Our Ref : S076158.015

File No : MP10\_0104

**RE West Circular Quay Public Domain Upgrade Works, Circular Quay /  
The Rocks (MP10\_0104)**

The City has reviewed the Environmental Assessment and notes the conceptual nature of the proposal. The City generally supports the design concept but cannot give its full support to the proposal in its current form due to the lack of design resolution and detail relating to some key aspects of the proposal.

6 . Paving

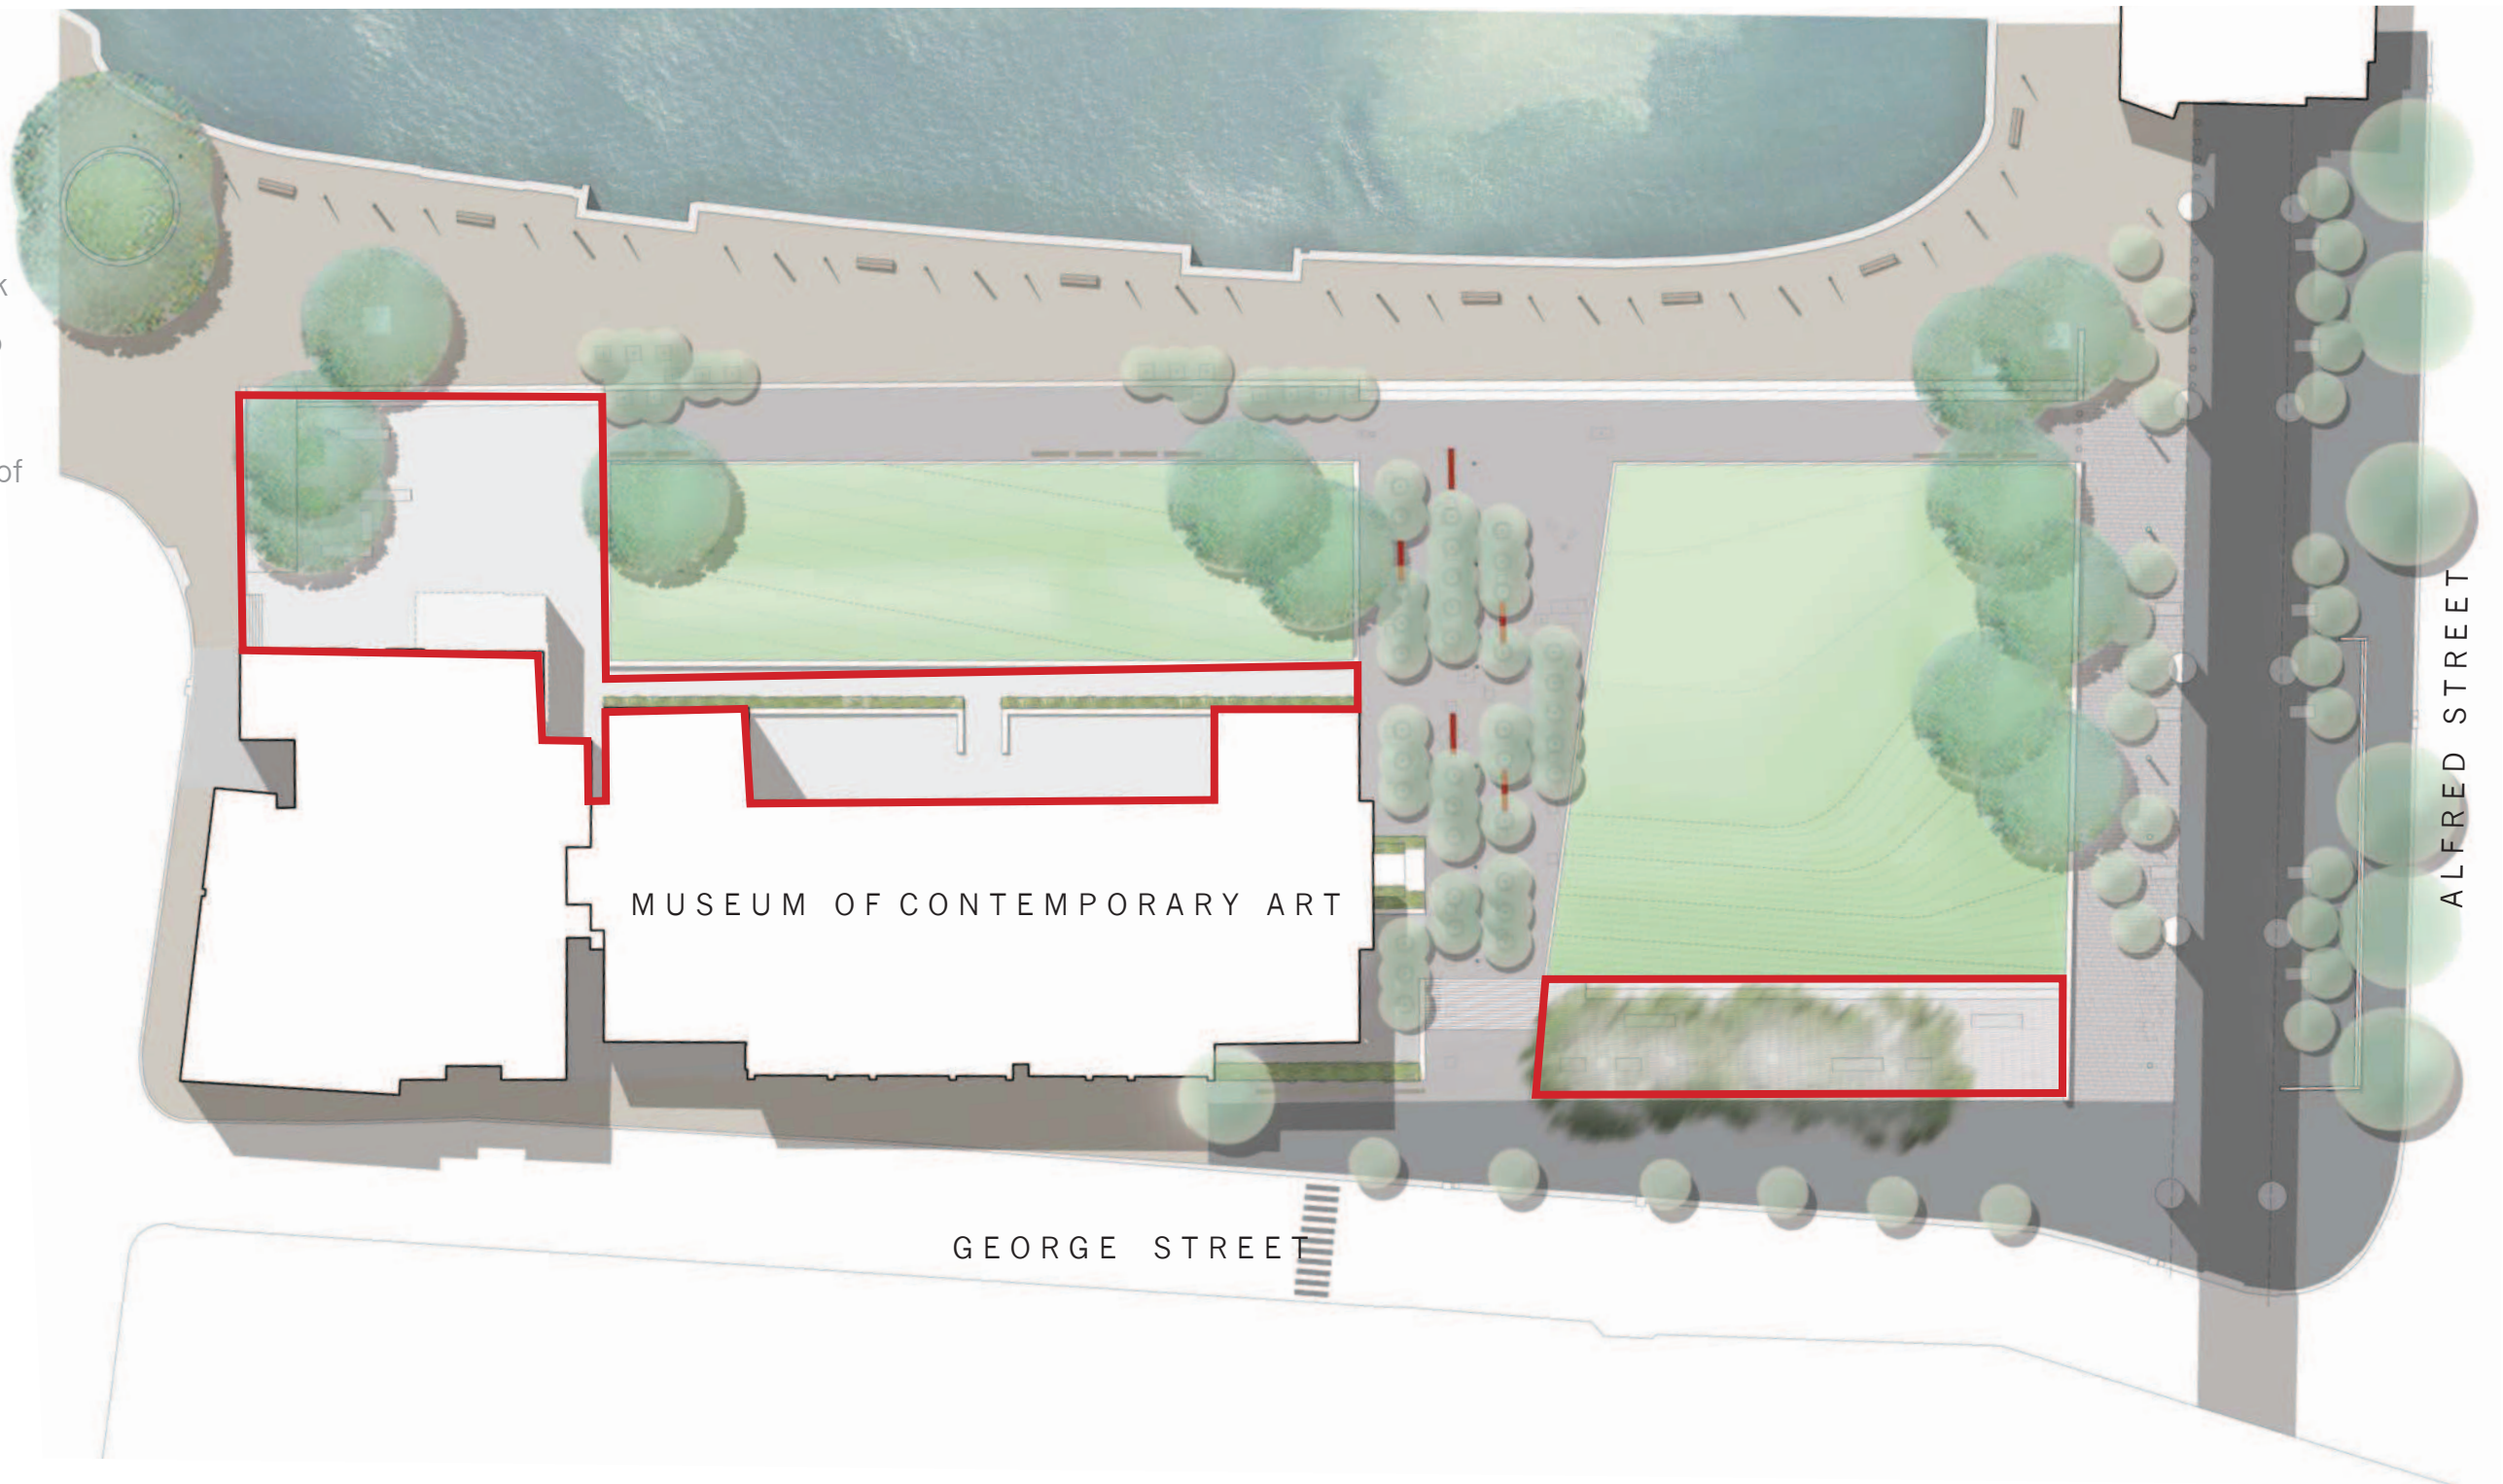
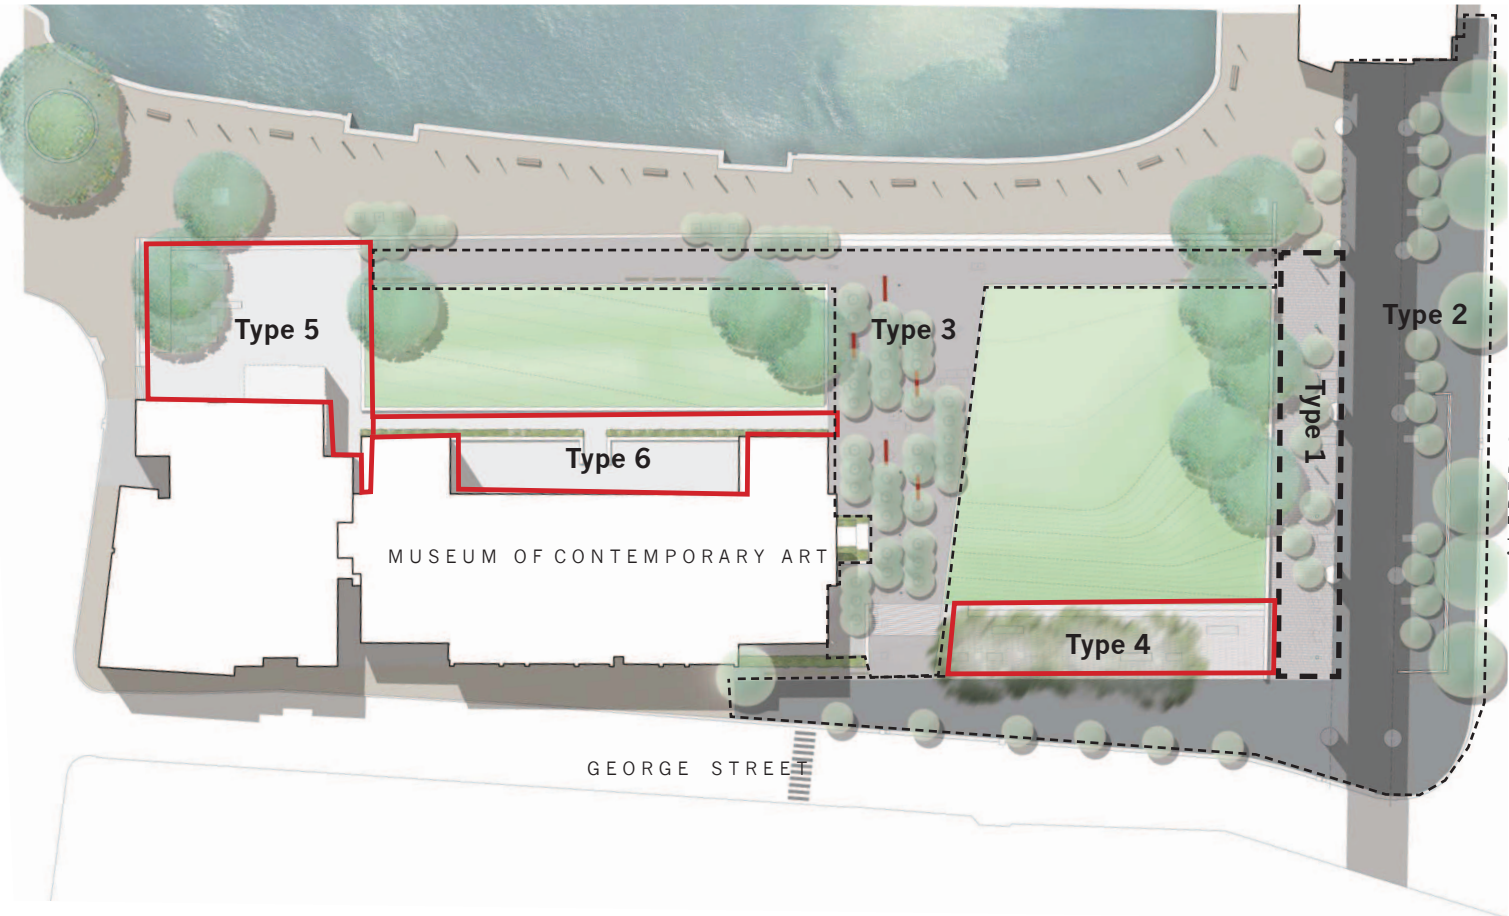
- a. The use of eight different paving types in a relatively small area of public domain appears to be excessive and may not create a simplified and unified space.
- b. The use of asphalt at the George and Alfred Street edges is not acceptable as it is not consistent or integral with the City’s paving standards which require granite at this location.
- c. Insufficient details are provided about the pattern, size and colour of all new paving types and extent of paving works, as well as internal inconsistencies in the documentation with regard to the footpath finishes along Alfred and George Streets.
